From: Planning
Sent: 27 July 2021 15:23
To: John Macholc
Cc: Planning
Subject: R&U Planning Applications 3/2021/0660 and 3/2021/0661

Subject: Planning Applications 3/2021/0660 and 3/2021/0661

Grindleton Bridge - Chatburn (TA Link Refs. 71, 123 + 122)

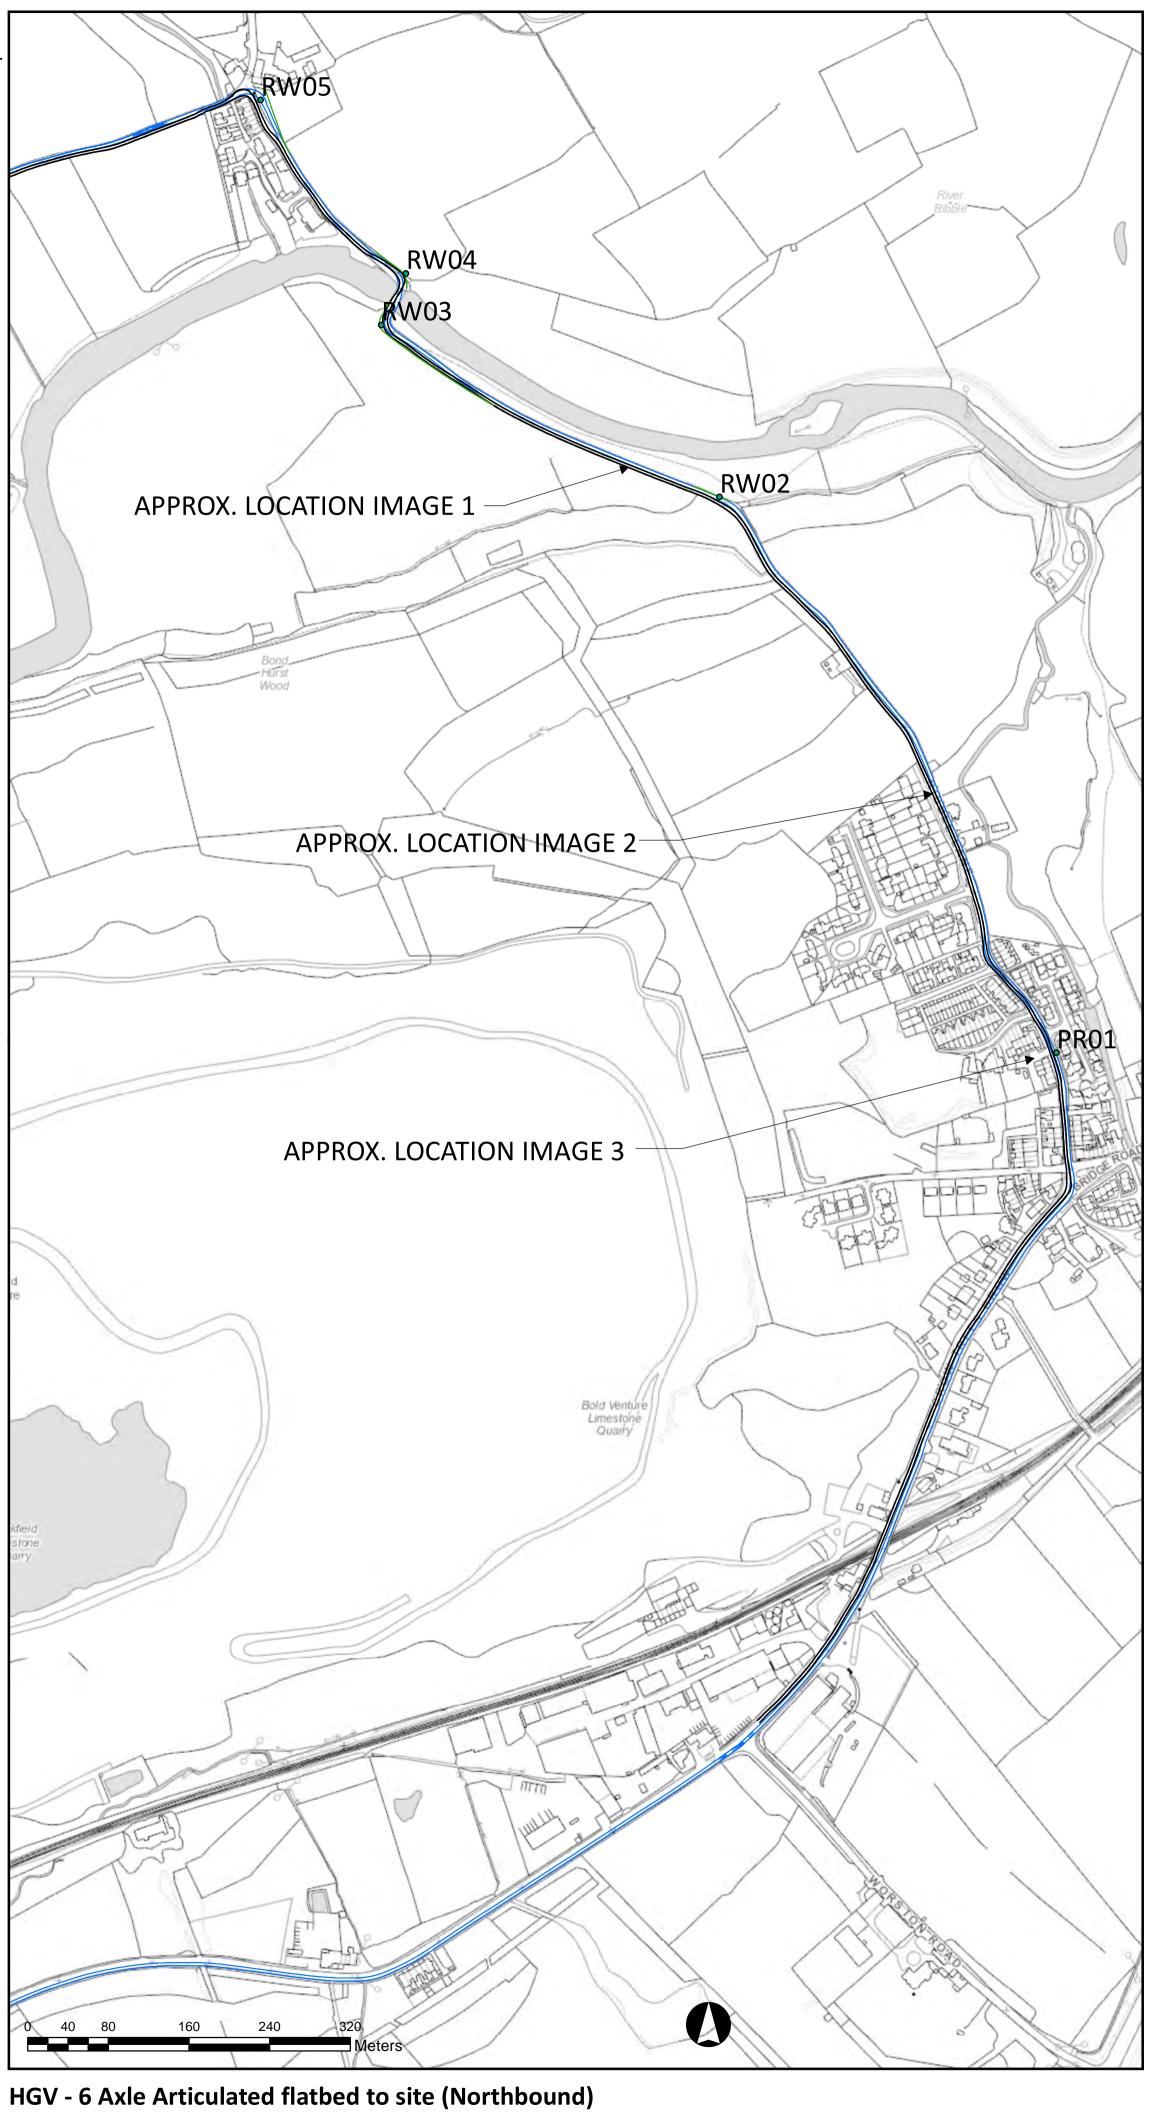
Parking, on road parking would become impossible in Ribble Lane, Chatburn and East View, Grindleton. Would there be long term provision for off road parking at these two locations, and where could that be?

Road Widening, the plans show widening before and after Grindleton bridge to allow vehicles to get enough angle to cross, if the original route is not fully re-instated afterwards it will spoil the area, and it will then become a regular crossing for even more heavy vehicles.

Existing road structures, are Grindleton bridge and all the other culverts and bridges along this route able to take the increase load. I understand that the temporary traffic lights at West Bradford school are because of a collapsing culvert, this has taken 18 months to start repair work.
